TO: All Staff
FROM: Public Works Planning Review Team
DATE: December 7, 2020
SUBJECT: BL-20-00028 Burchak

The Public Works Department has reviewed the Request for Boundary Line Adjustment Application. In order to ensure that it meets current Kittitas County Road Standards, the applicant needs to provide the following prior to final approval:

# BURCHAK BLA SITE PLAN

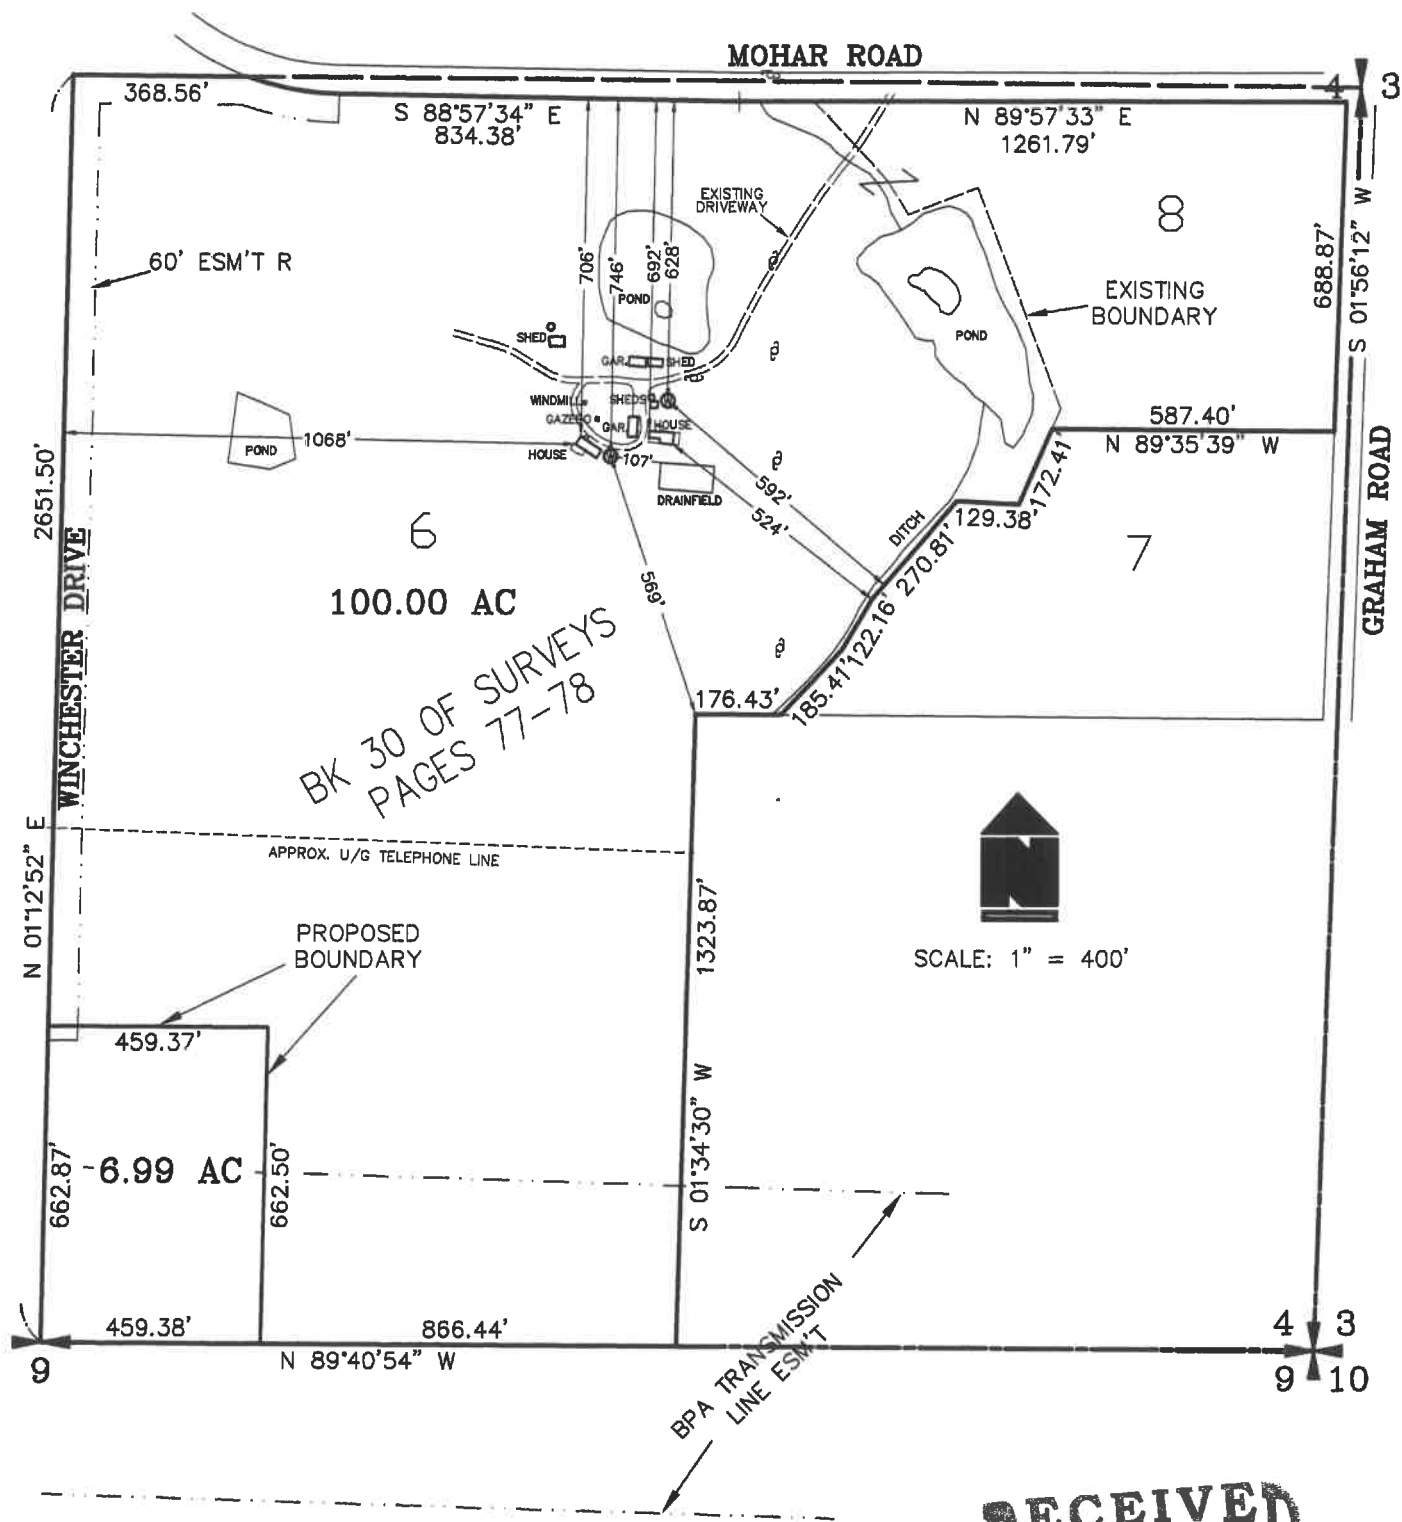
1. A revised legal description that describes the final configuration of the subject property shall be required.
2. A survey map for review. Any comments regarding survey will be reserved for final.
3. Show access easements on the face of the BLA.
